**WELWYN HATFIELD BOROUGH COUNCIL
EXECUTIVE DIRECTOR - PLANNING, PUBLIC PROTECTION AND GOVERNANCE**

Application No: 6/2020/2119/PN8
Location: 24 Worcester Road Hatfield AL10 0DX
Proposal: Prior approval for the erection of a single storey rear extension 6m in depth, 3.7m in height and 2.7m eaves height
Officer: Mr Tom Gabriel

Recommendation: Prior Approval Refused

Existing
Brickwork to walling
Roofing tiles
UPVC Glazing and doors, white

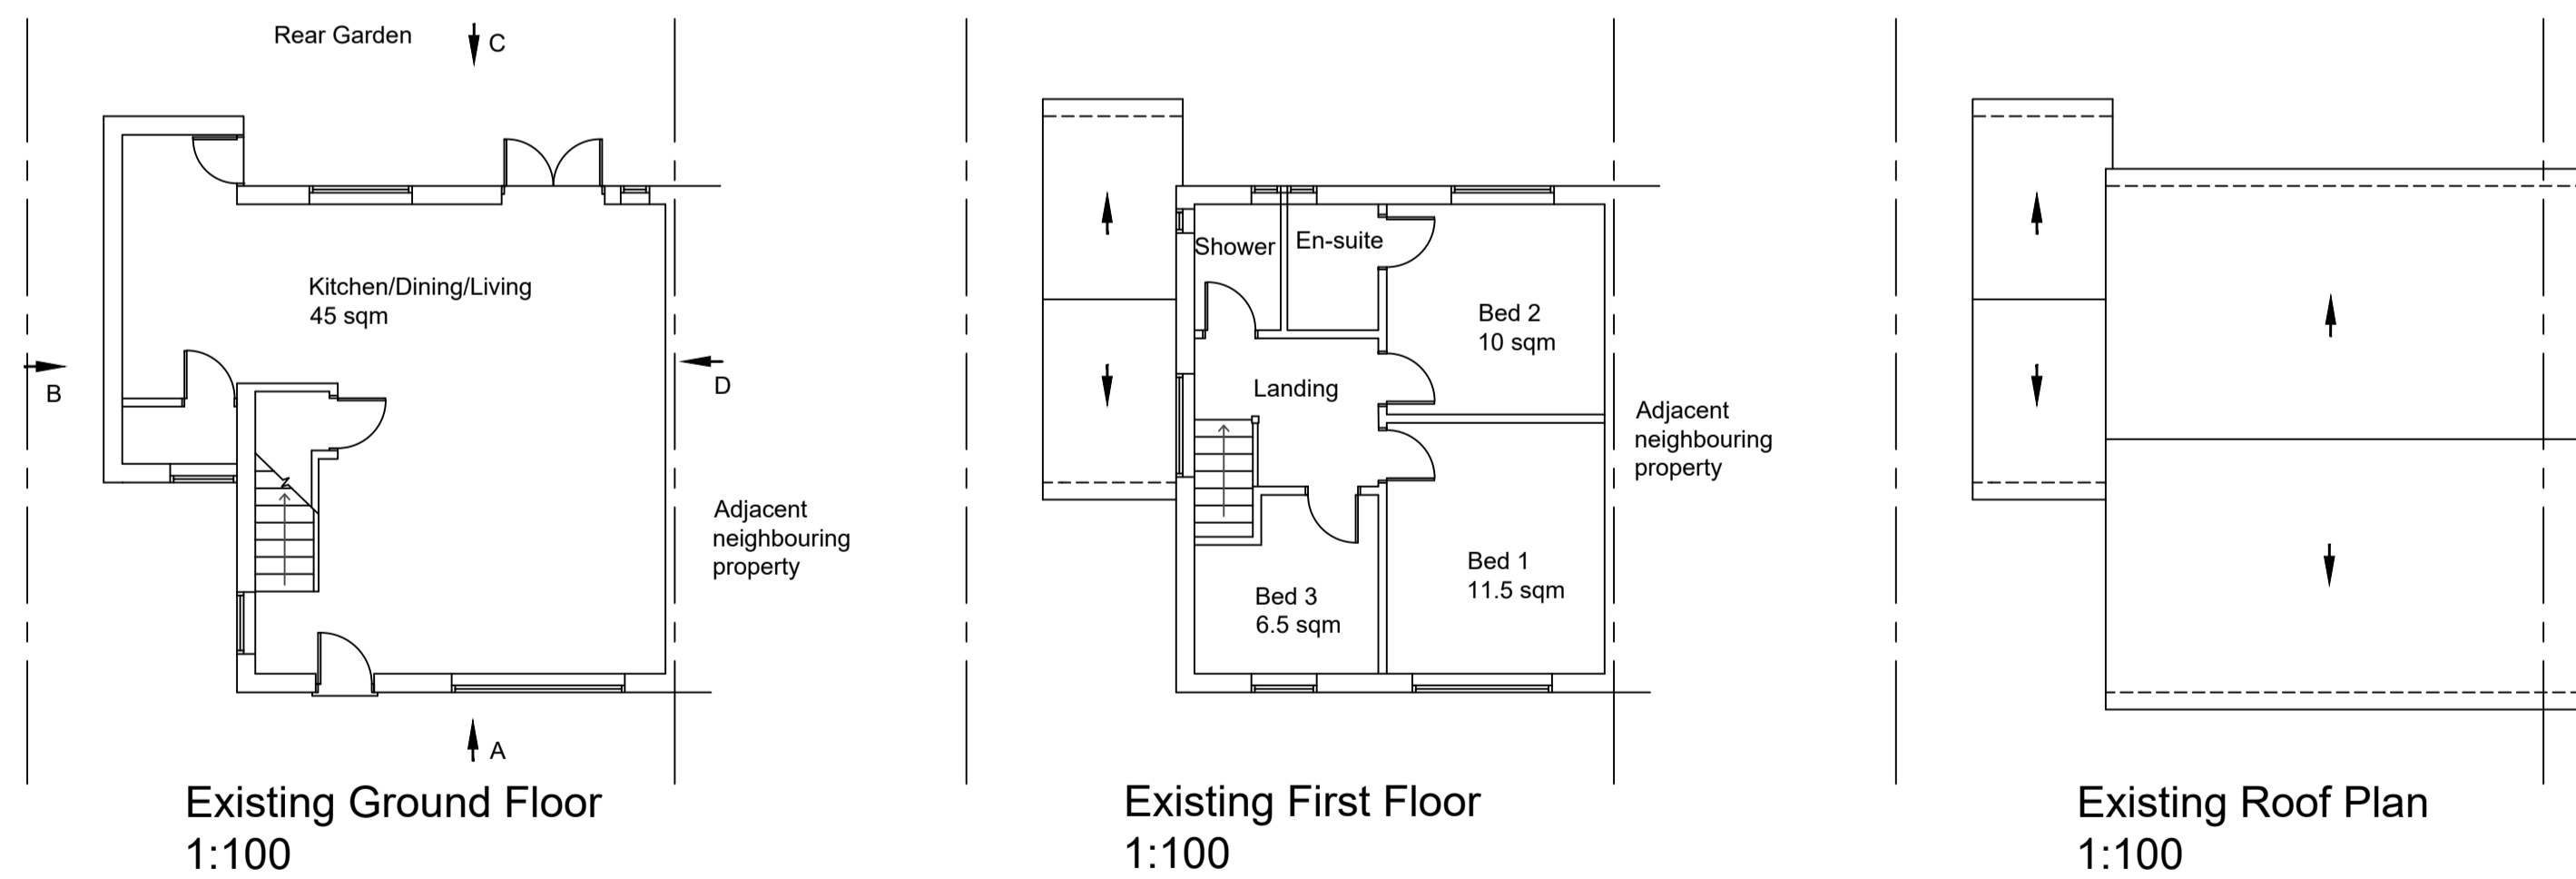
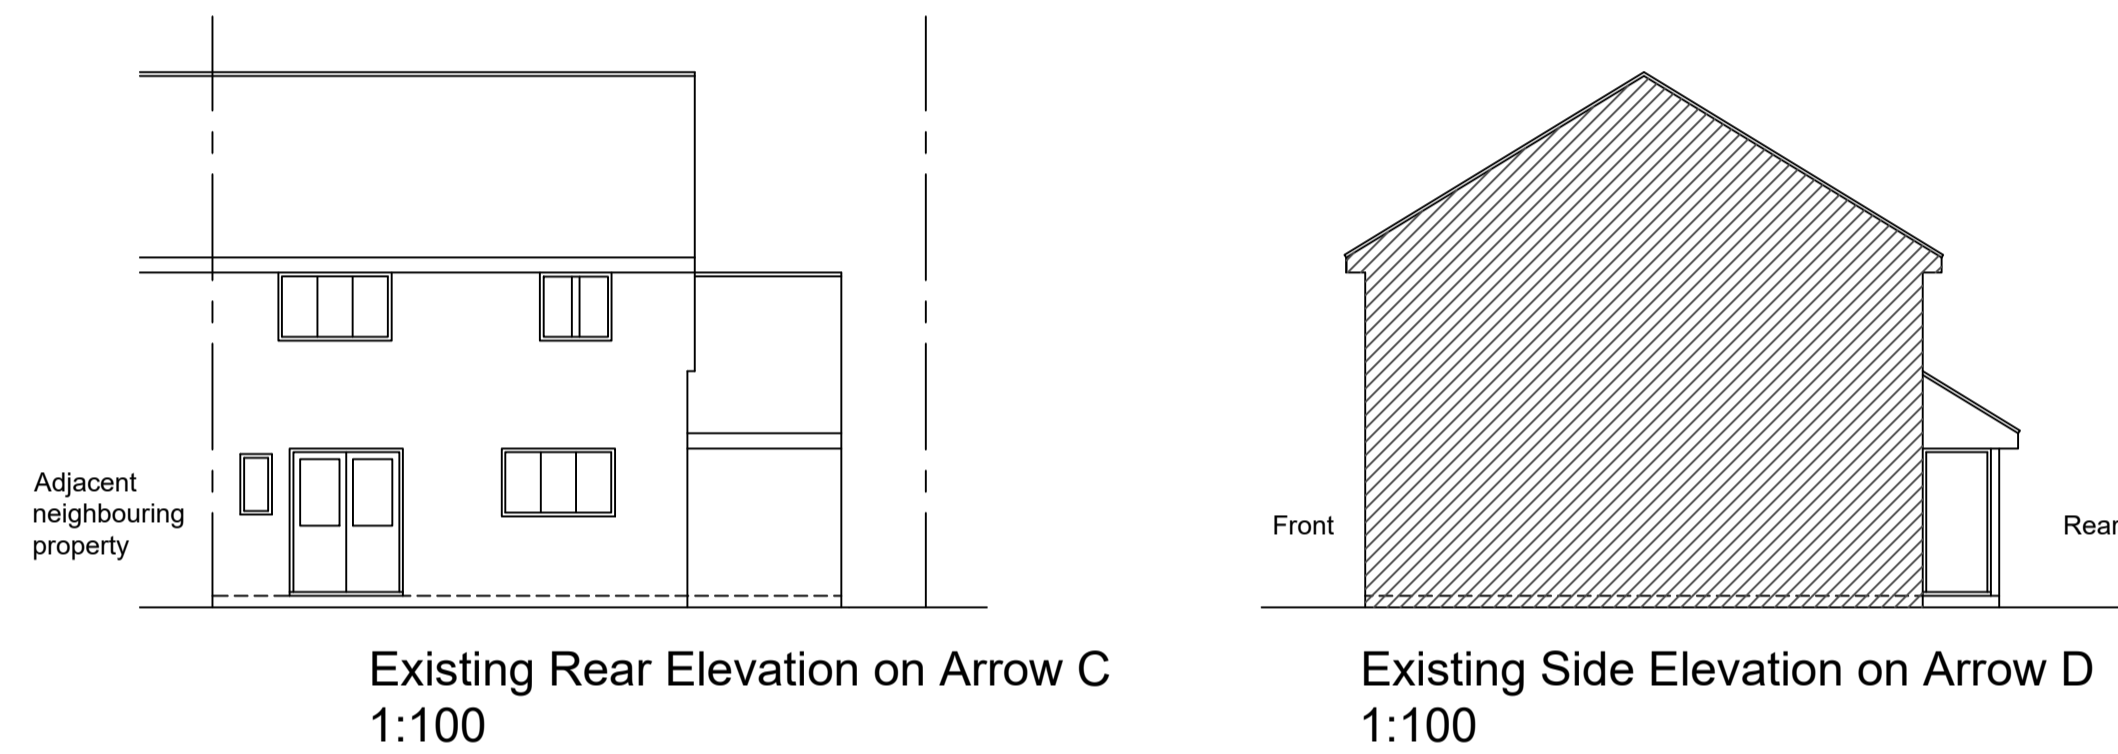
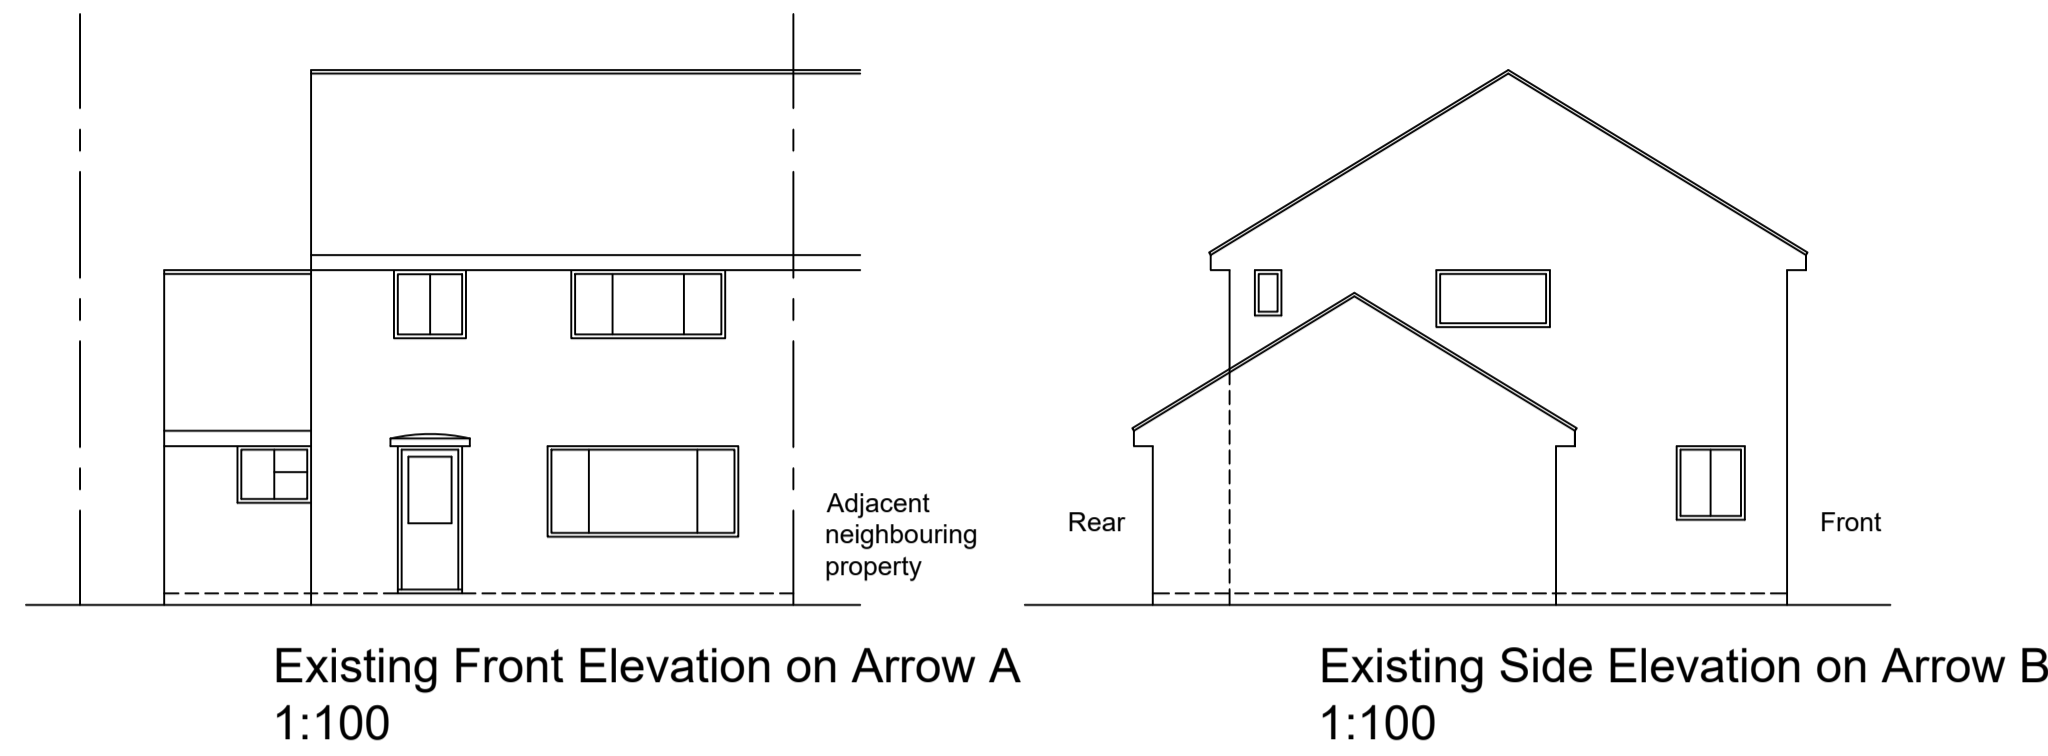
(j) would the enlarged part of the dwellinghouse extend beyond a wall forming a side elevation of the original dwellinghouse, and:- (i) exceed 4 metres in height, (ii) have more than one storey, or (iii) have a width greater than half the width of the original dwellinghouse The existing single storey side/ rear projection at the dwelling appears to be an original part of the building as its materials and those of the dwelling match and there are corresponding elements at many of the neighbouring and surrounding dwellings. On this basis, it is considered that the single storey side/ rear element of the dwelling is an original part of the dwelling. While the proposed extension would attach to this side/ rear element of the dwelling, it would not extend beyond a wall forming a side elevation of the original dwellinghouse as the side/ rear element is original. The extension would not form a 'wraparound' extension.	Y	N

The proposed extension would extend beyond a side wall and therefore falls to be considered against the limitations set out in paragraph A.1(j) of the GPDO. Notwithstanding that the proposed extension would comply with the limitations set out in paragraph A.1(g), the construction of paragraph A.1 is such that development is not permitted by Class A if it fails to meet any of the clauses (a) – (k). As the extension would have a width greater than half the width of the original dwelling/house it would exceed the limitation on the width set out in clause (iii) of paragraph A.1(j). Therefore, the proposal is not permitted development and an application for planning permission is required.

1. The proposed development fails to comply with the Schedule 2, Part 1, Class A.1(j) of the General Permitted Development Order 2015, as amended. The reason for this is because the proposed extension would have a width greater than half the width of the original dwellinghouse.
